Response to Planning Application *Revised comments 24/05/22*

From: Arun District Council Greenspace

Application ref: A/48/22/RES

Location: Land off Arundel Road Angmering BN16 4ET

Amenity & public open space area and LAP located at the centre of the site

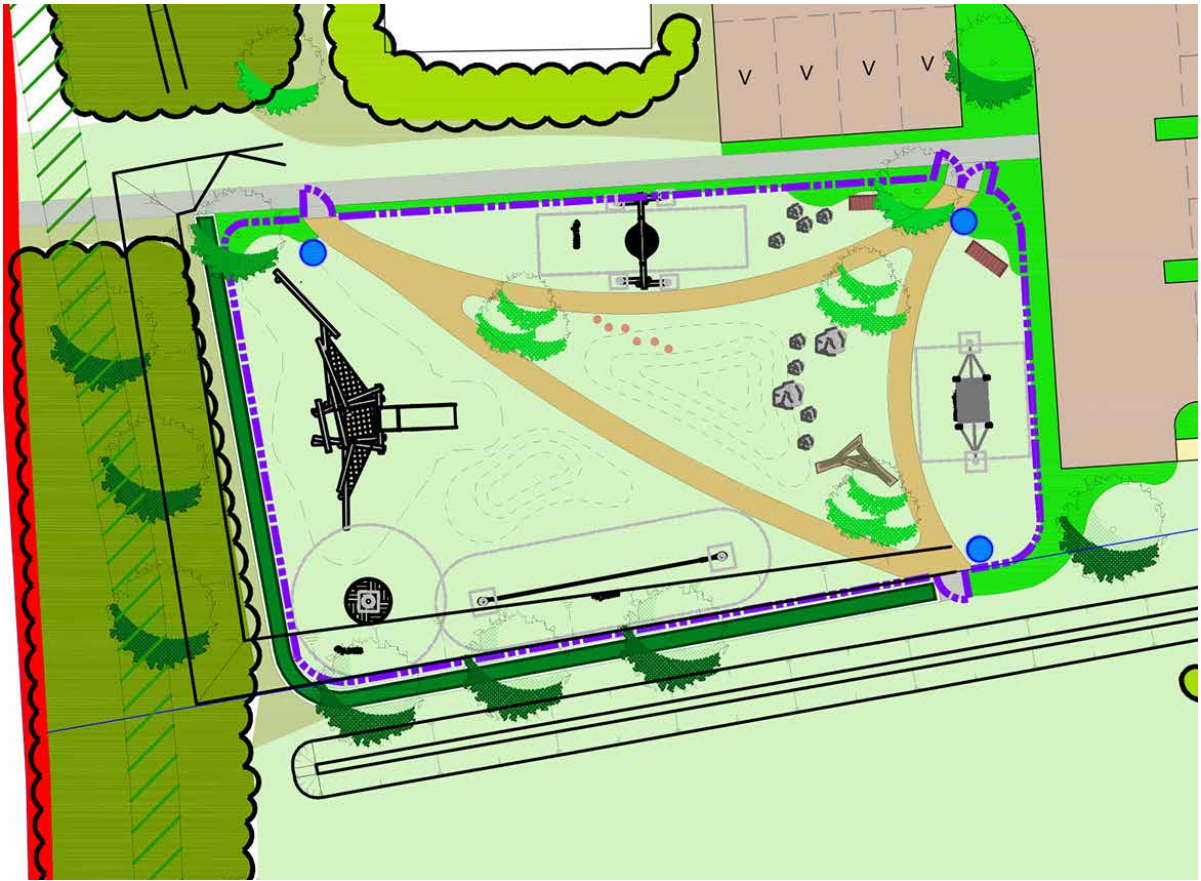
Planting Plans 1 of 6 and 4 of 6 JSL 3924 – 501 & 504 Rev A indicate the **play provision** for the development site, however this **needs to be provided in much greater detail, ensuring that the play offer proposed is both inclusive and accessible** with suitable safety surfacing, street furniture and fencing as required to be submitted and approved.

Recommend that the landscape context of the wider site is re-considered including the street scene formation, tree planting plot reliance and all areas of POS and buffer planting. **Further detail is required re the POS and Play provision** and pathway connectivity. **Recommend that the commercial element is further explored re the entrance proposals and access connection to the Sports Hub area.** Recommend that the outline application is considered re the residential entrance POS to ensure that the site is not compromised by the depletion of the green buffer in this location.
